Appeal Decision

Decision date: 13 December 2021

Appeal Ref: APP/R5510/W/21/3278659

103 Lansbury Drive, Hayes UB4 8RW

Proposed_Front_Elevation

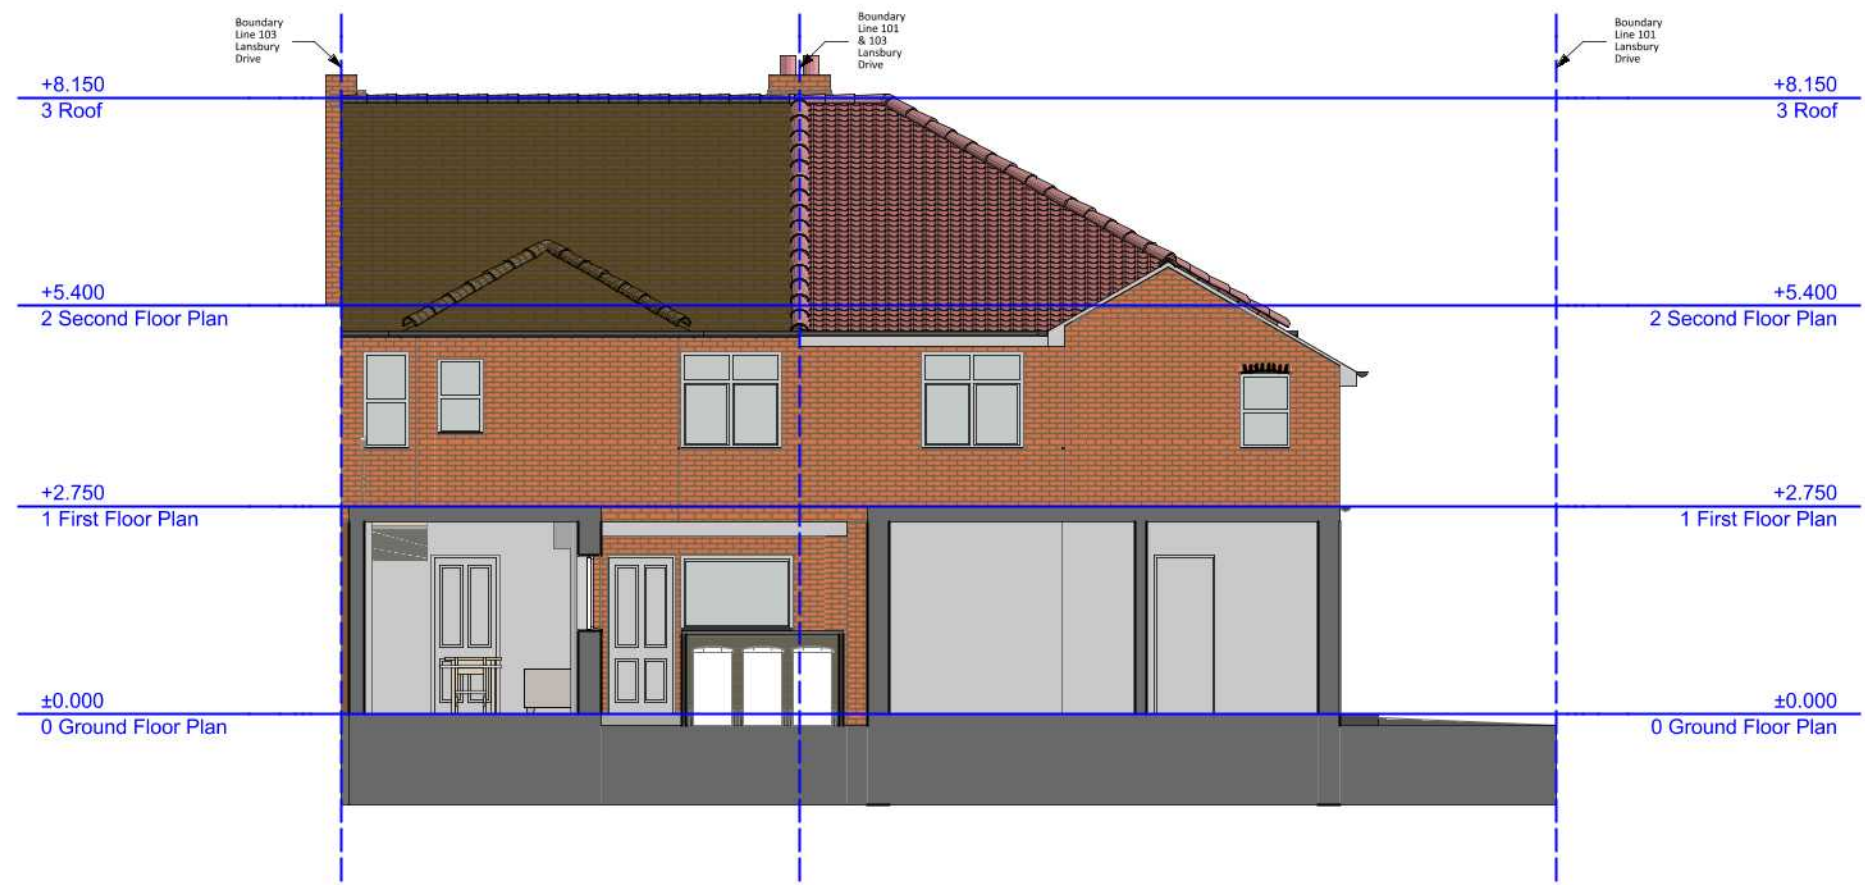
11. The Council are concerned that the proposal would include building operations relating to the adjoining commercial unit and also operations which would not be reasonably necessary to convert the building to a dwelling. The alterations to the shopfront at No. 103 fall within the extent of the application site boundary and provide access from Lansbury Drive to the proposed ground floor flat. Whilst these works would also facilitate a relocated access to the existing flat at No. 103a, I see no reason why they would not be reasonably necessary to convert the building to a residential use. I accept that the proposed ground floor flat would also be accessed from the existing rear yard access, but this does not render the creation of an access from the front either unreasonable or unnecessary.

Proposed_Street_Rear_Elevation

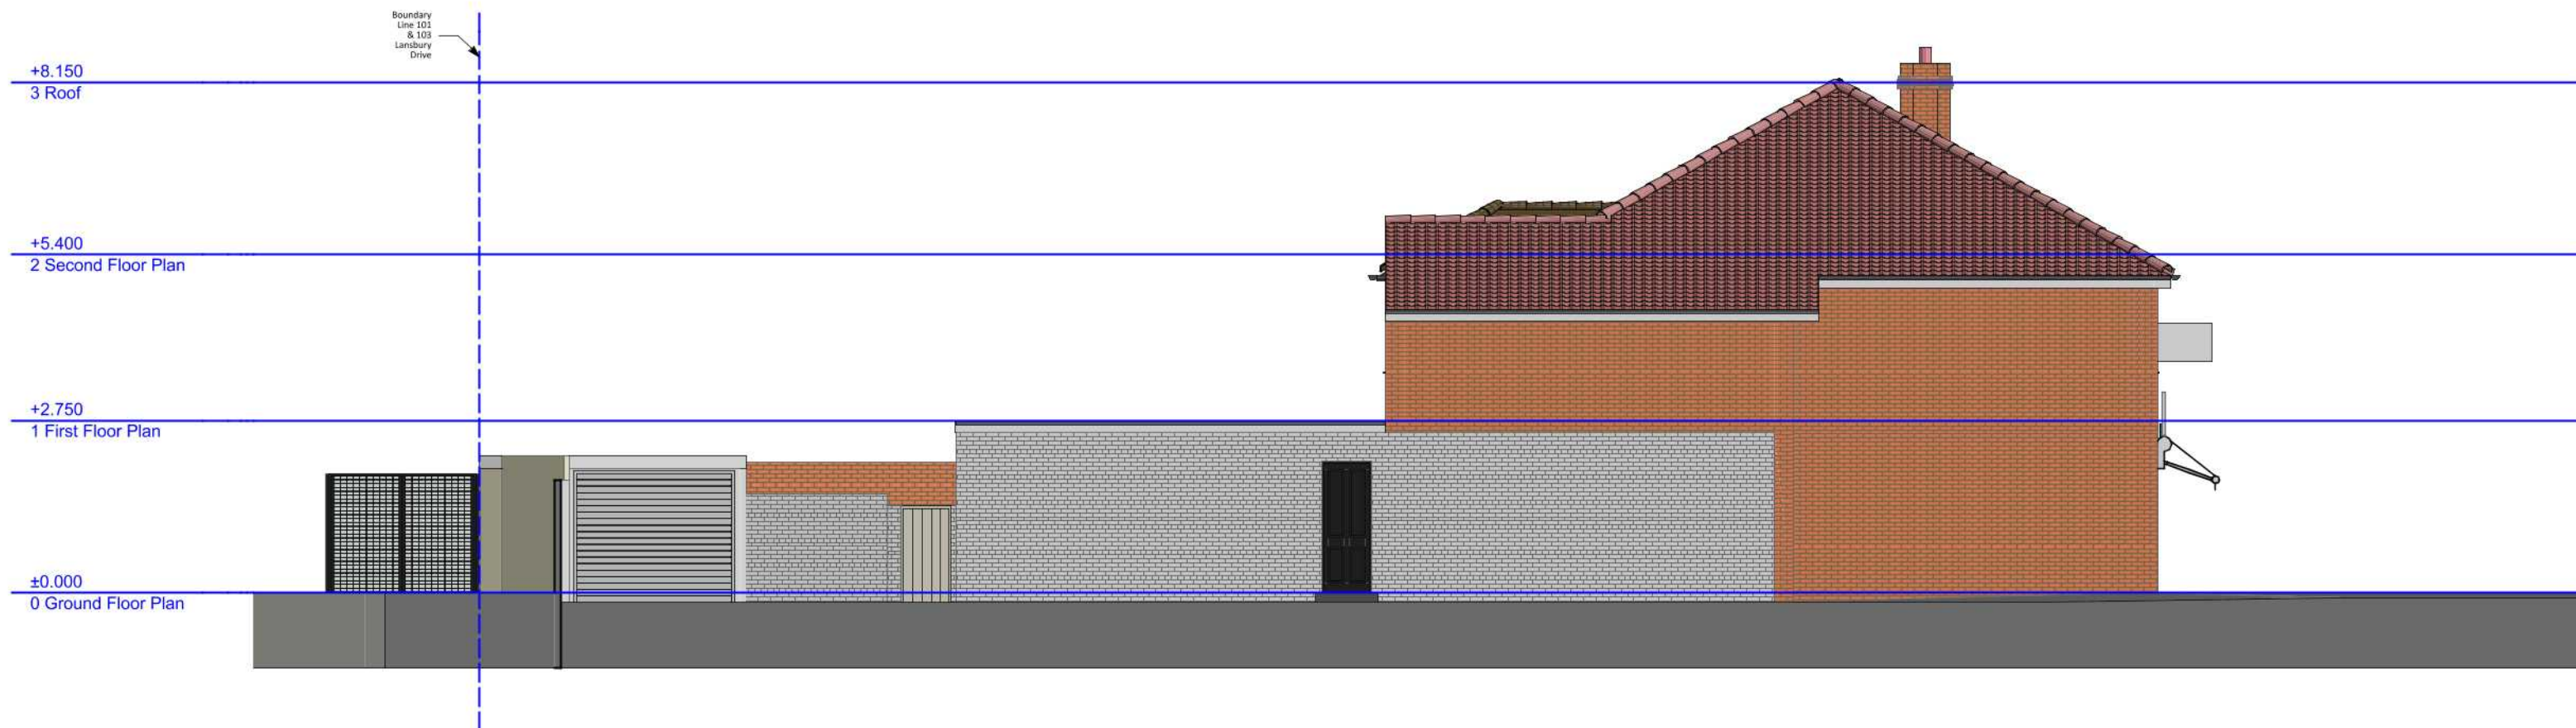
14. The proposed ground floor flat would comprise of an open-plan living / dining / kitchen / sleeping area, with a separate bathroom, storage area and entrance hall. This single area would be served by two windows, one on the rear face and one on the side facing elevation of existing ground floor build-outs.
15. Although the outlook from these windows would be reasonably open across intervening yard walls and single storey flat-roofed outbuildings and garages at neighbouring properties, the open-plan living area is deep and the windows would not be particularly large. As the plans also show that the area immediately outside these windows would be utilised for refuse storage and car

parking, it is also likely that there would be further impediment to light from these windows.

16. The appellant has not in any event submitted any compelling evidence to demonstrate that these windows would provide sufficient daylight penetration to the living area. As such, I cannot be certain that the proposal would provide adequate natural light to the ground floor flat and that the proposal would comply with the provisions and conditions set out at paragraph M.2(1)(f) of the GPDO.

Site Plan/Block Plan of 103 Lansbury Drive, Hayes, UB4 8RW

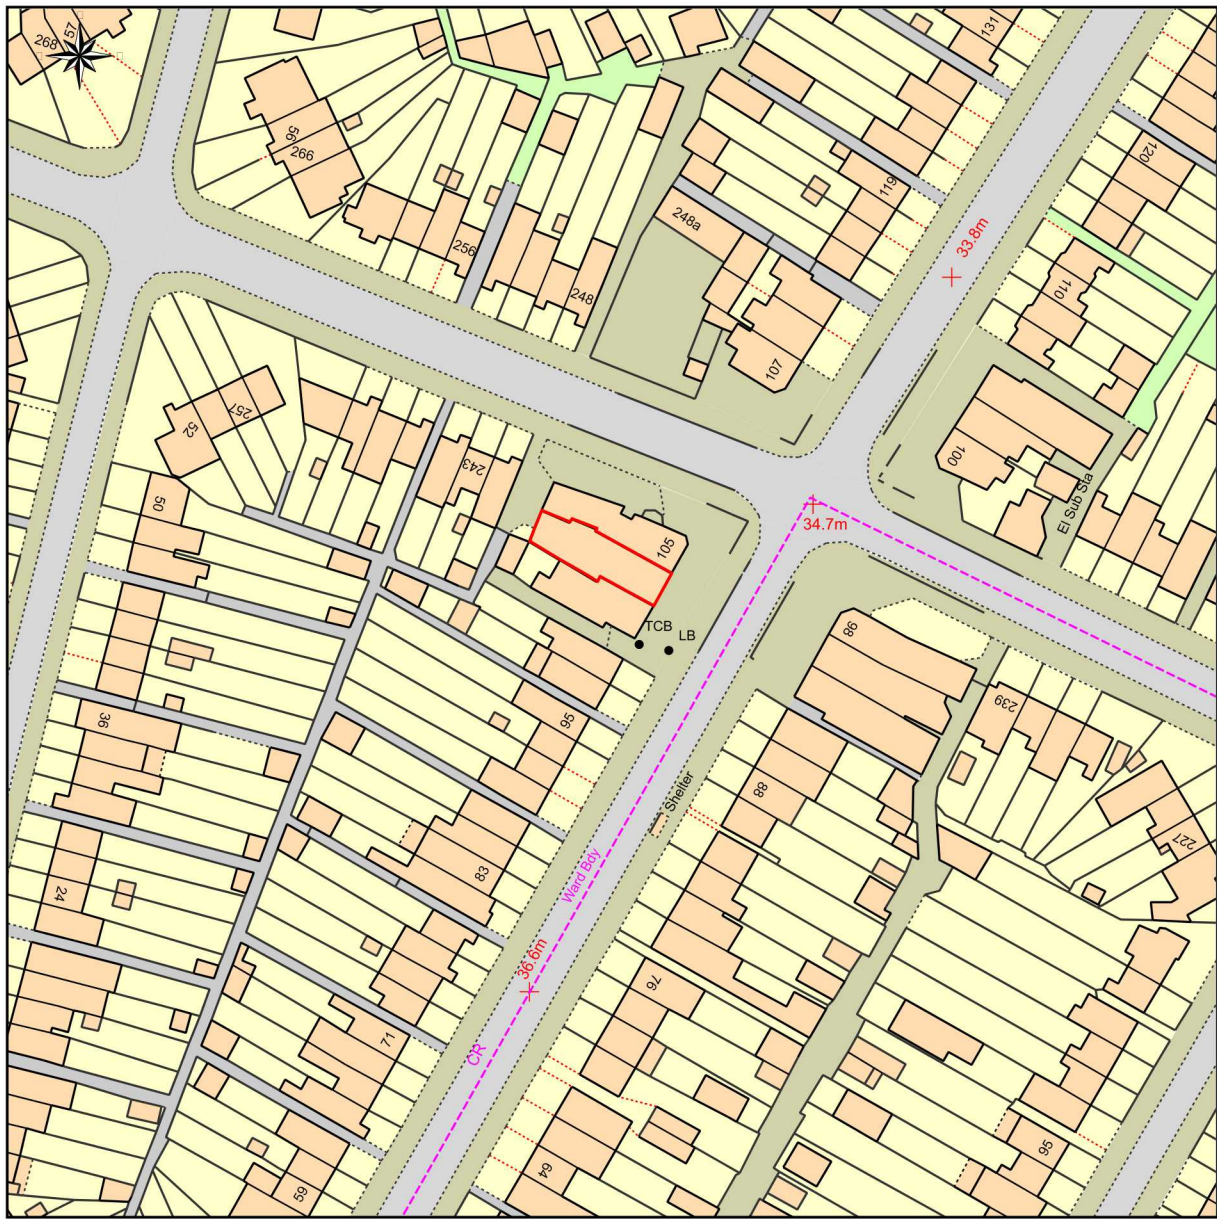
10. The proposal seeks to convert the storage and welfare areas at the rear of No. 103, as well as a small portion of the existing retail floorspace, to create a ground floor studio flat. This would be accessed from the rear (private access) and the front (shared access with No. 103a). The existing shopfront at No. 103 would be altered to accommodate a doorway entrance. The extent of the application is shown⁵ to include the middle unit of the terrace of three (No. 103) and the alterations

12. There are changes internally to the proportions of the retail unit that are shown on the submitted plans but that are not within the extent of the application site. However, I have no evidence before me that they amount to, or facilitate, a change of use to a dwelling and, in any event, lie outside the application red line boundary shown on the submitted plans.
